18 November 2013

## **Determination of Modifications to the Design of Stage 1, Vincentia District Centre (Mod 5)**

Figure 6: Arbour Way pedestrian pathway (Stage 1)

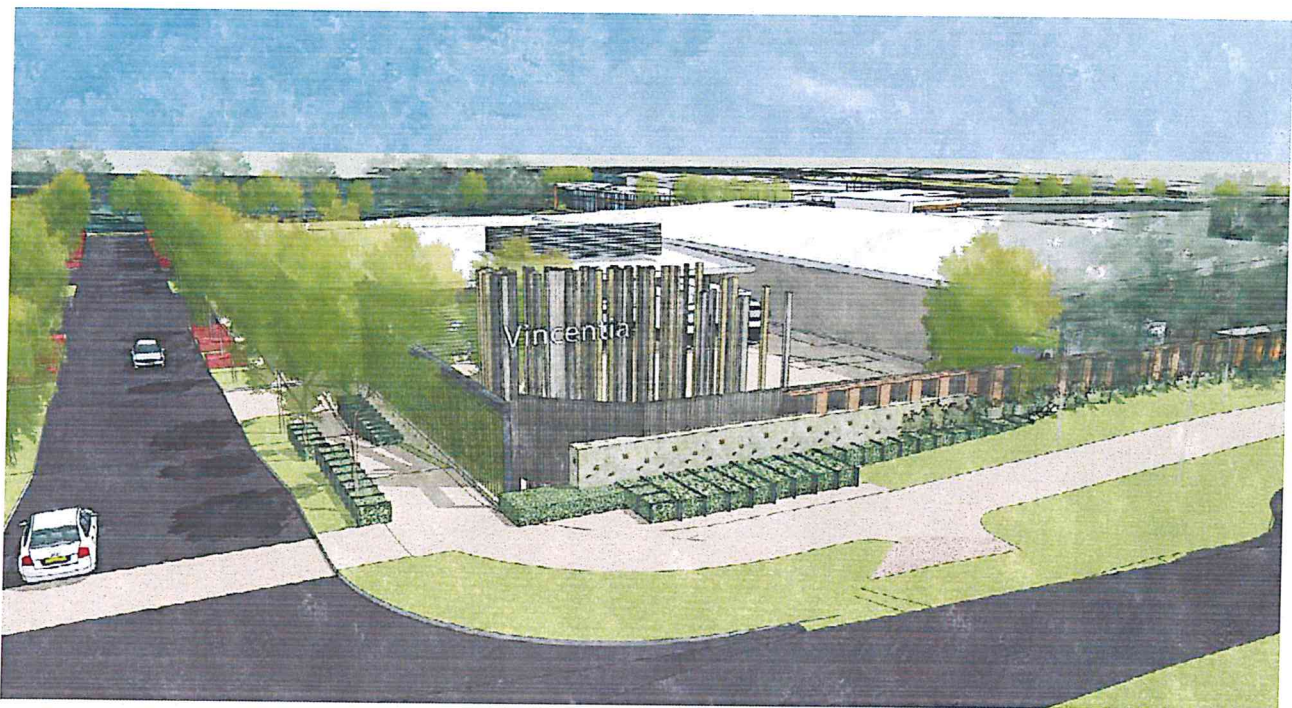
According to the plans in the assessment report Stages 1 and 2 are connected with a cover over the Arbour Way. This design obstructs both the view corridor proposed to the water body and open space, and free-flowing pedestrian and cycle movement. The updated plans provided by the proponent on 11 November 2013 propose Arbour Way to be open as a two way, per the proponent’s commitment to Council, with a pedestrian crossing at the entrances to Stages 1 and 2.

The Commission agrees that the Arbour Way should be kept open to maintain the view corridor to the water front open space. It supports a share-zone between the entry/exit of the loading dock and the waterfront in Stage 3 to improve the quality and amenity of the outdoor environment for both pedestrians and shoppers. This will also require greater activation of the building frontages of Stage 2 to improve pedestrian safety and experience.

Similarly, the Arbour Way link between Stage 1 and the waterfront area should be widened by deleting a row of parking spaces, and landscaping enhanced. An amendment plan to reflect these changes shall be submitted to the Director General for approval prior to the

Approved Section 75W Modification Application

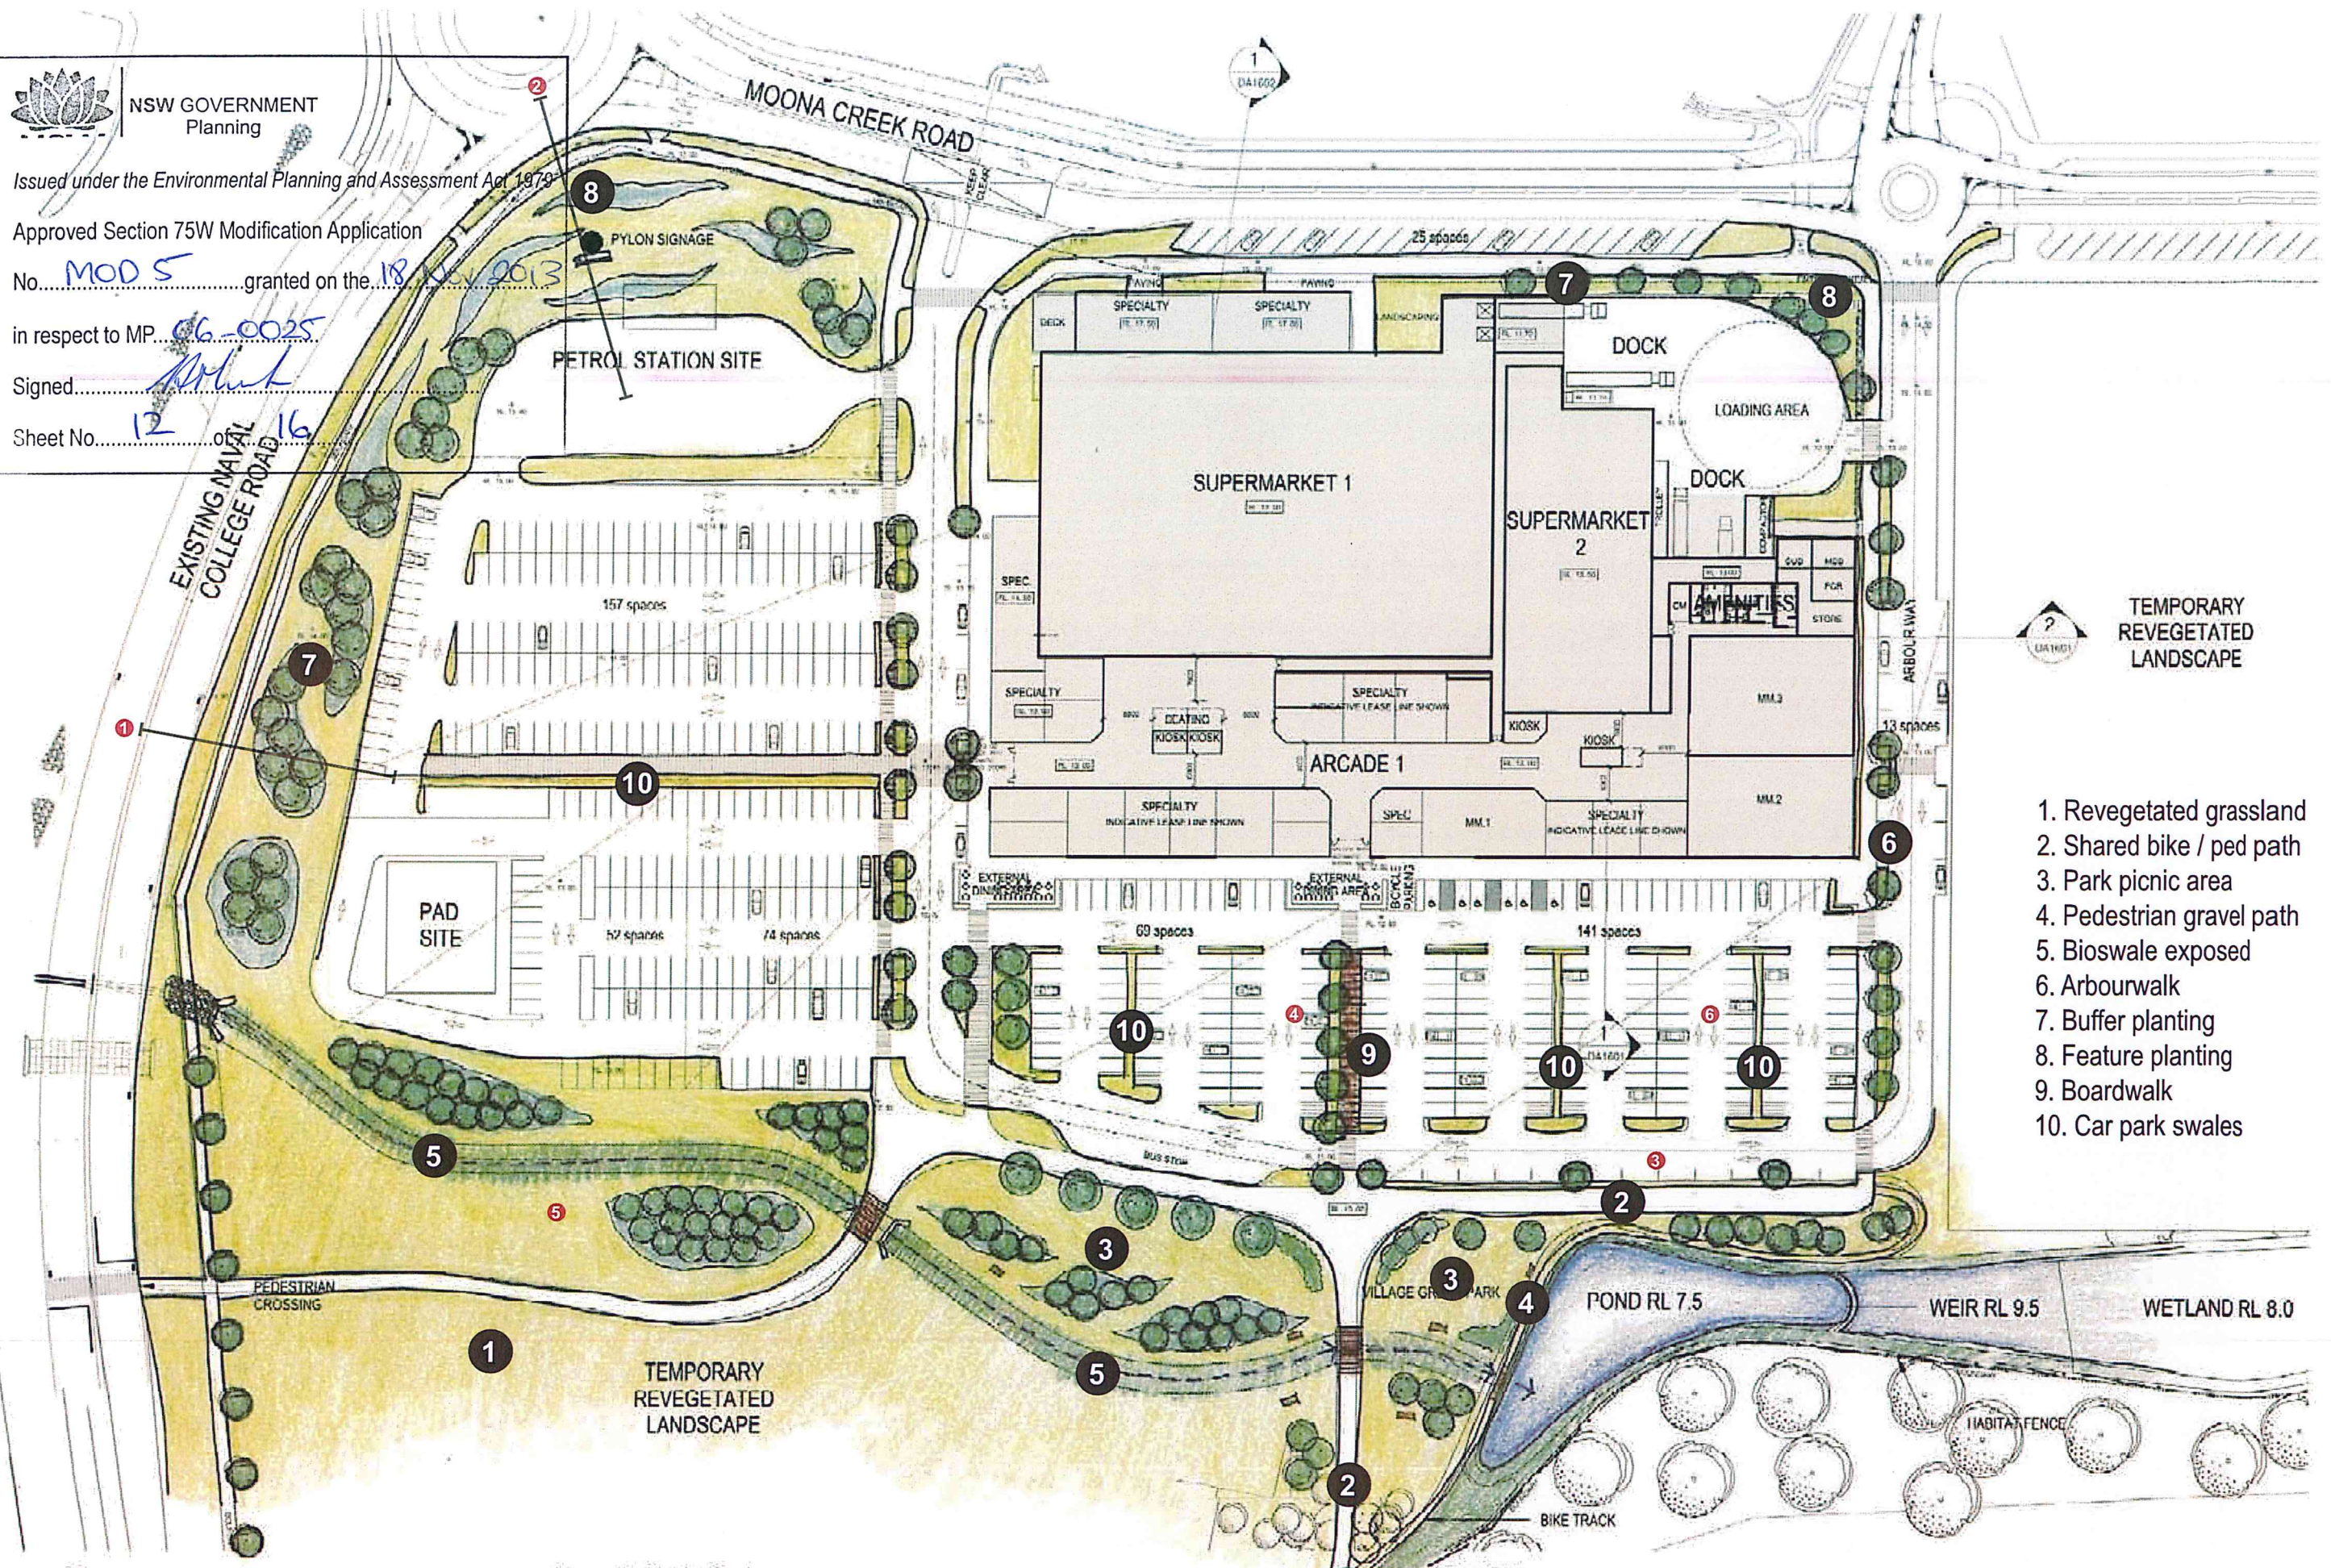
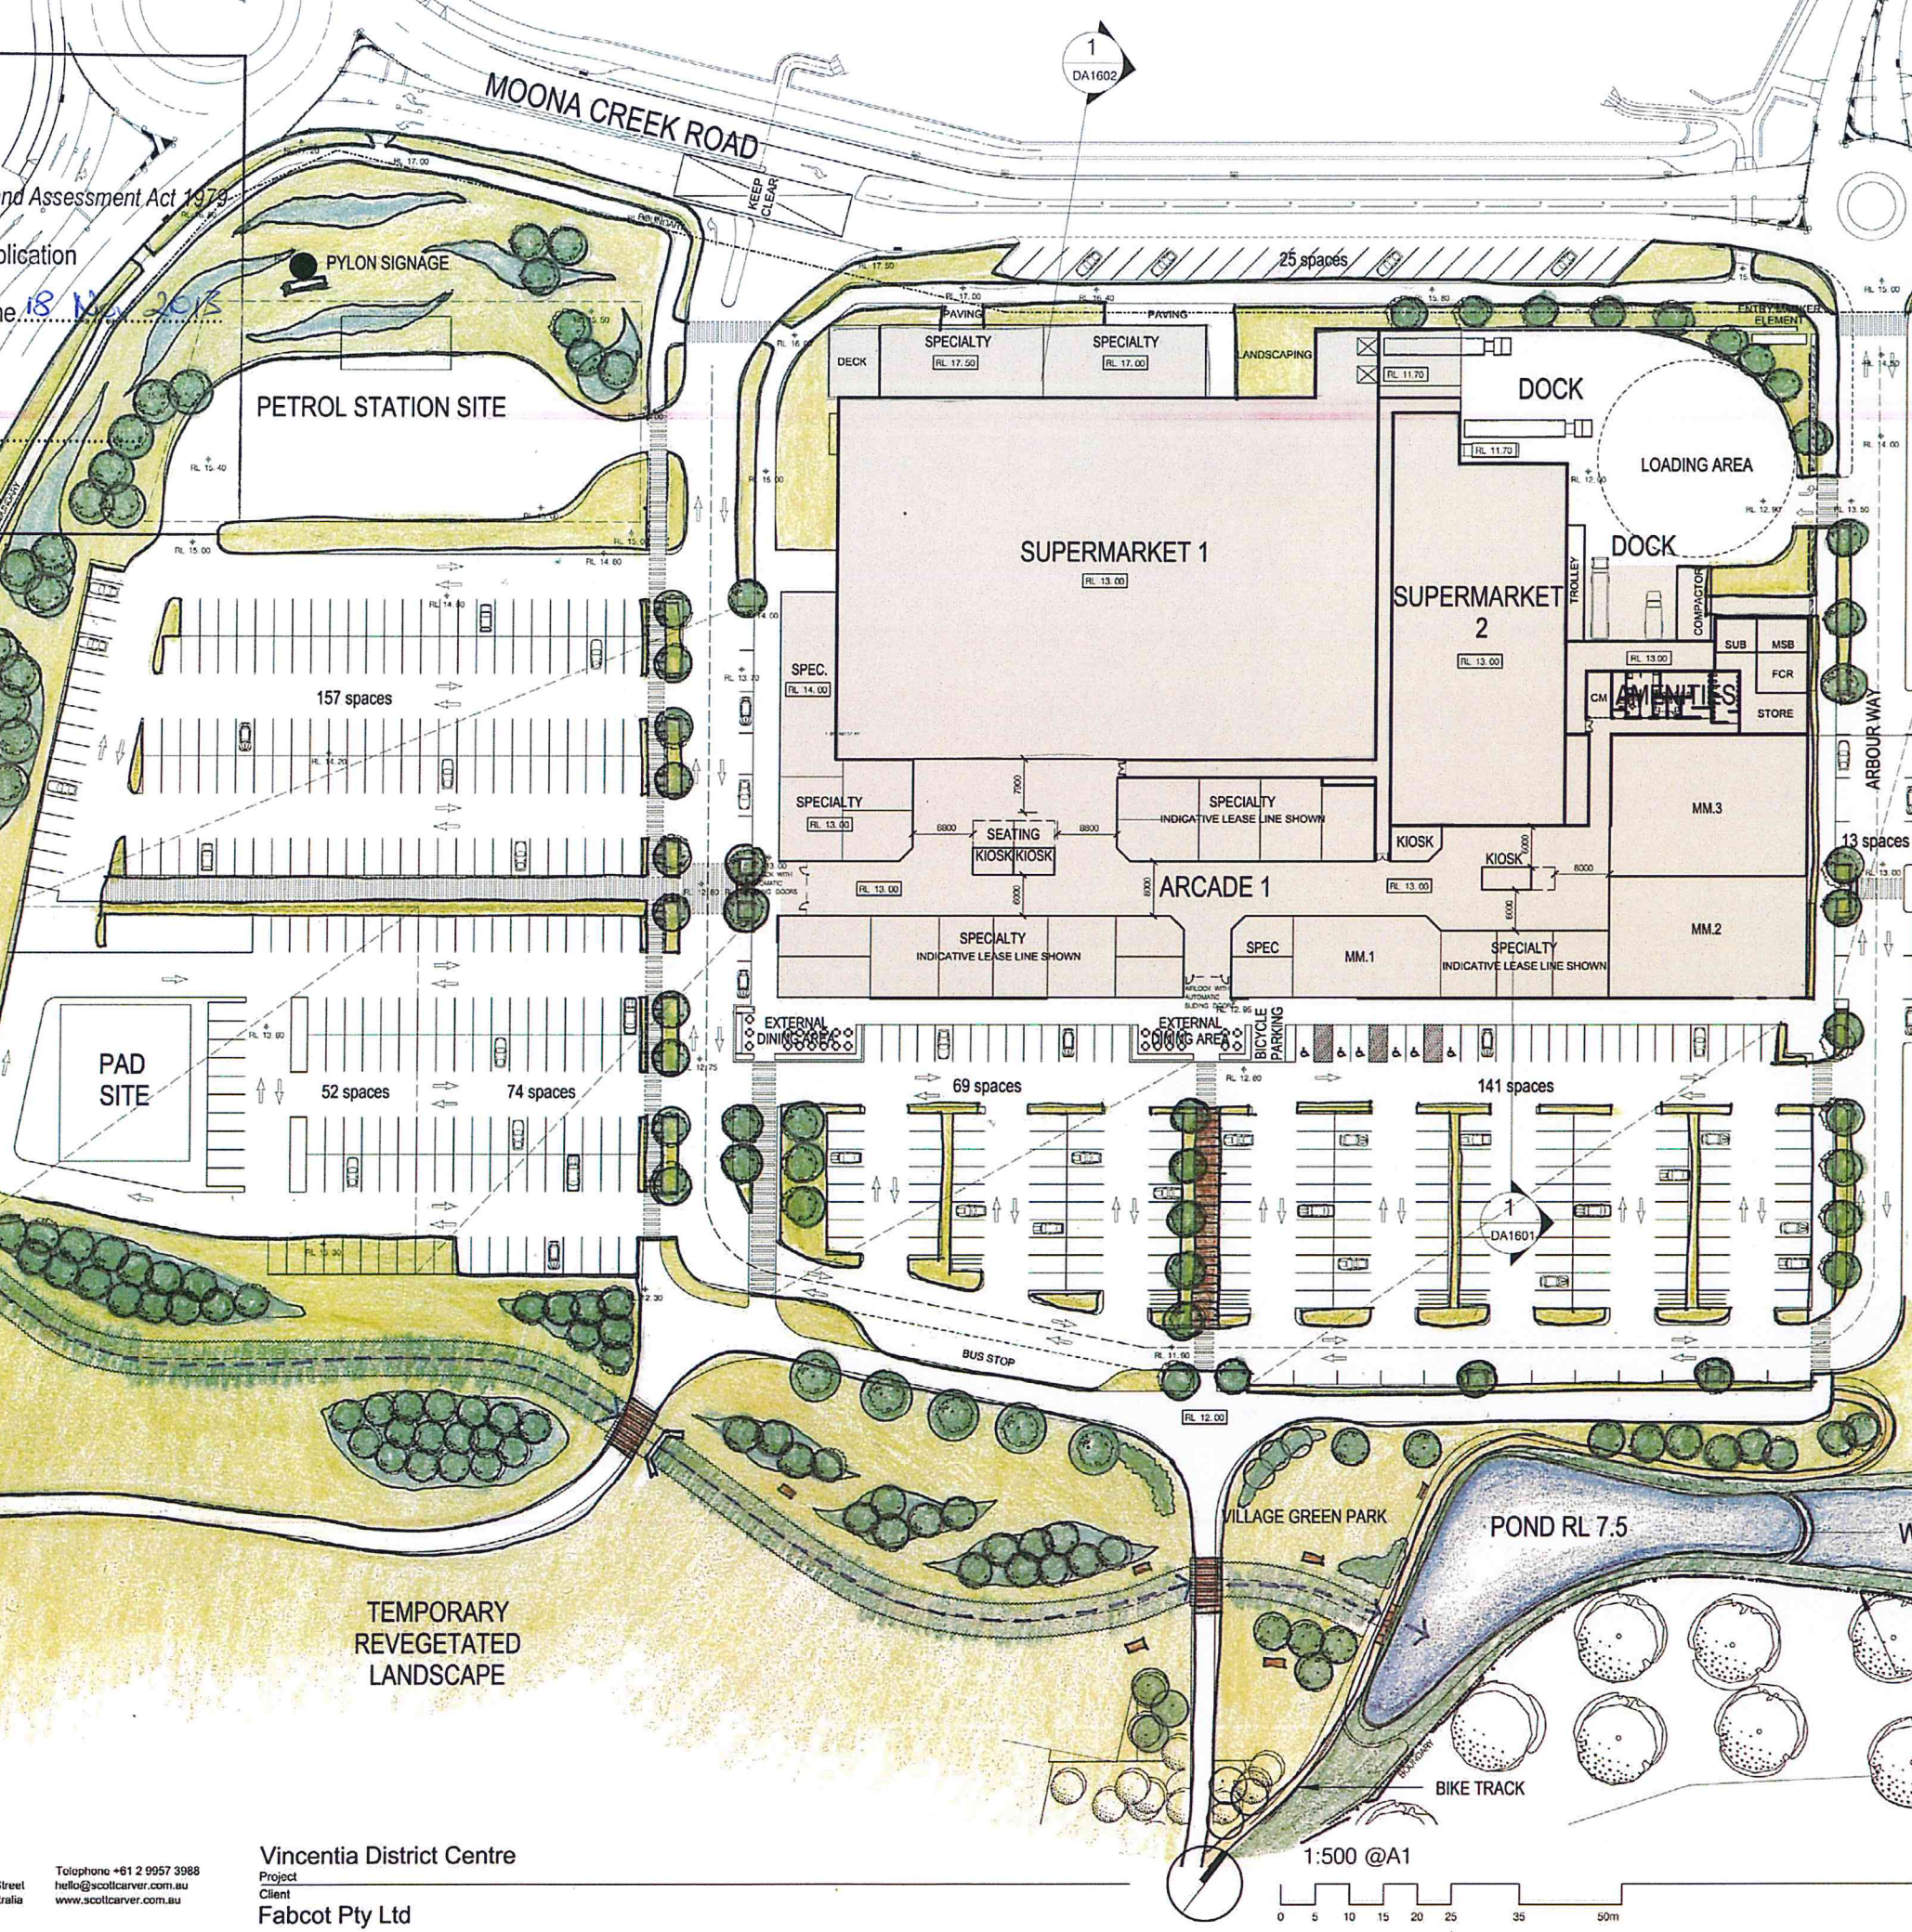
The Commission considers it reasonable to allow the PAD1 to be identified as future development site as its location may be suitable for a petrol station for local residents and the travelling public. However, it does not support PAD2 as it is isolated from the main town centre. The Commission agrees with Council that this will create the potential for ribbon development, particularly given there are already 2 PAD sites approved in the concept plan in Stage 4, and acknowledges community concern in this regard.

As discussed in the earlier section, this site should be used to provide a deeper landscaped area along Naval College Road, and parking spaces to replace those lost due to the widening of the pedestrian connections between Stage 1 and the library/waterfront area. An amendment plan to reflect this should be submitted to the Director General for approval prior to the issue of the first construction certification.

The area identified as 'Future Development Site' (known as PAD2) located adjacent to Naval College Road at the south-west corner of the Stage 1 car park shall be deleted.

- the deletion of the 'future development site' (identified as PAD2) (in stage 1 fronting the Naval College Road) and replace it with additional landscaping area and parking spaces;
- the widening of pedestrian connections with appropriate landscaping between Stage 1 and the library, and between Arbour Way and the waterfront;
- the Arbour Way between the entry/exit of the Stage 1 loading area and the water front is a share-zone in Stage 3.
